RE: DRB – Project #1009290 – Southwest Mesa/Snow Vista Substation

In response to EPC Conditions of Approval at the July 12, 2012 hearing, PNM's responses are below.

**Project# 1009290 \***  
12EPC-40030 Site Development Plan for  
Building Permit

DATE: August 31, 2012  
TO: Jack Cloud, DRB Chair  
FROM: Catalina Lehner, Senior Planner *cel*  
RE: Project #1009290, PNM SW/Snow Vista Substation  
Site Development Plan for Building Permit

*Pecos Gold Utility Block # 250
LRV unavailable for all utility block descriptors

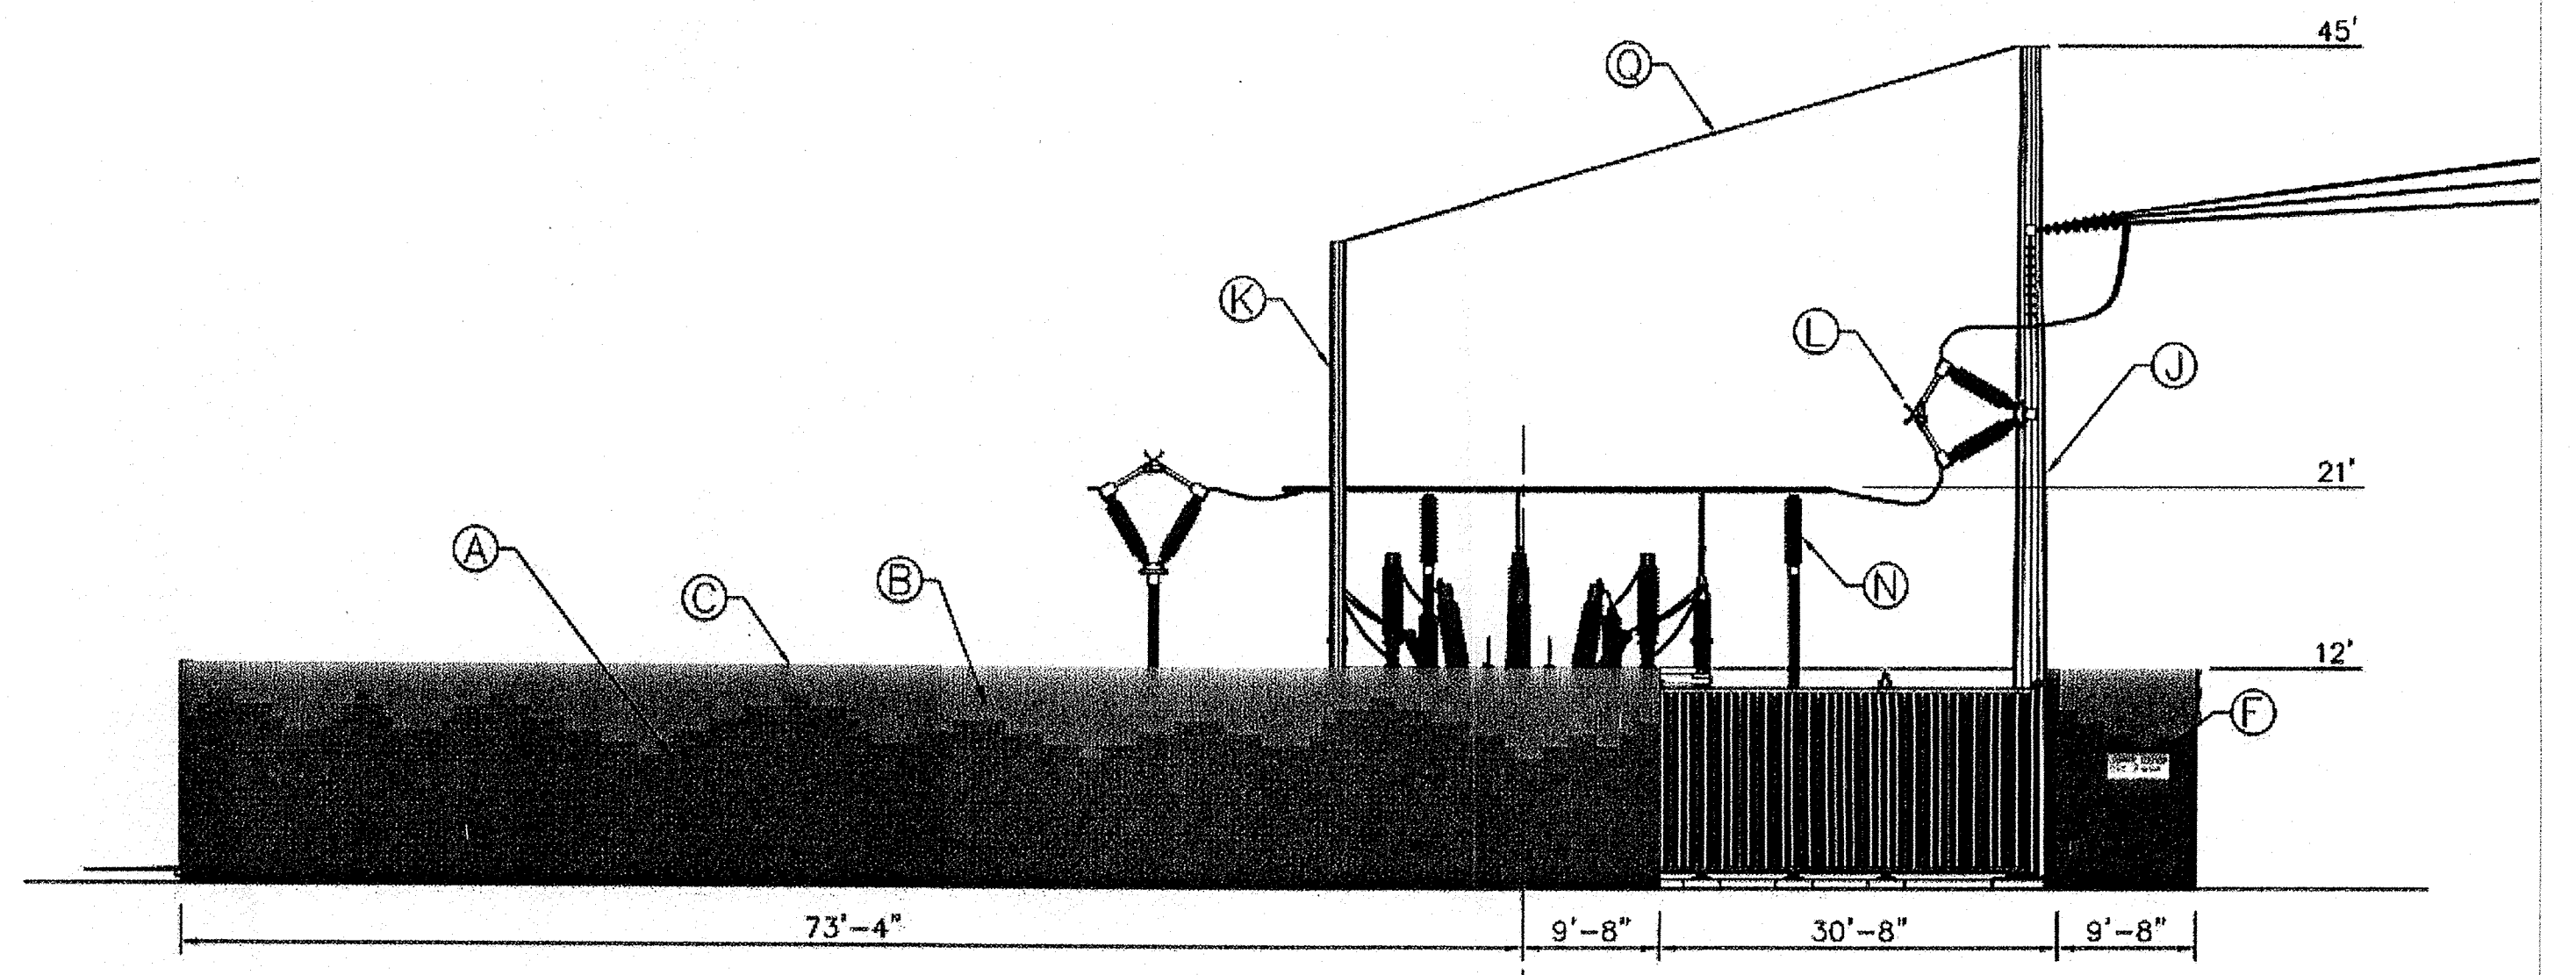
- A. *The continuous wall cap shall provide a minimum 2 inches from the public side of the wall [§14-16-3-19(B)(2)(b), the façade subsection].*

- B. *At least one feature from §14-16-3-19(B)(2)(a), the layout subsection, is required for each wall.*

B. *Specify if "Brevity Brown" is light, medium or dark.*

PNM Response: On Sheet 6 and Sheet 7, the following note has been added:  
"Continuous overhang cap will project two inches from the wall."

PNM Response: The substation wall contains variation in the façade surface and in the texture by complying with §14-16-3-19(B)(2)(a), 1. d., in which the wall design incorporates a two-tone multi-textured block mountain image as a decorative feature in the wall design; therefore, the wall design meets the requirement of §14-16-3-19(B)(2)(a). Vertical pilasters with a projection of 2 inches will be placed at intervals of 20 feet as noted on sheet 6 and 7.

PNM Response: Medium brown has been added to Items D and E on Sheet 6 and 7.

STATION SIGN

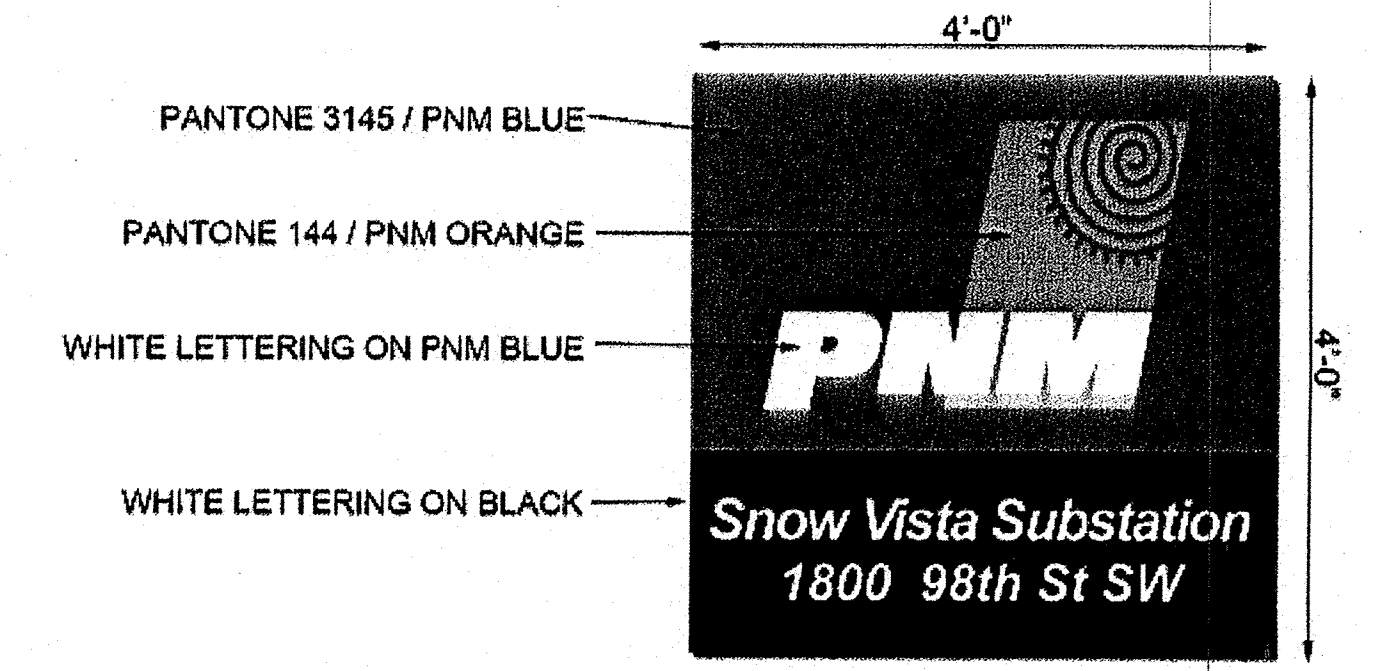
Condition 6, Signage: Provide a detail for the PNM sign.

PNM Response: On Sheet 7, the PNM sign details have been added.
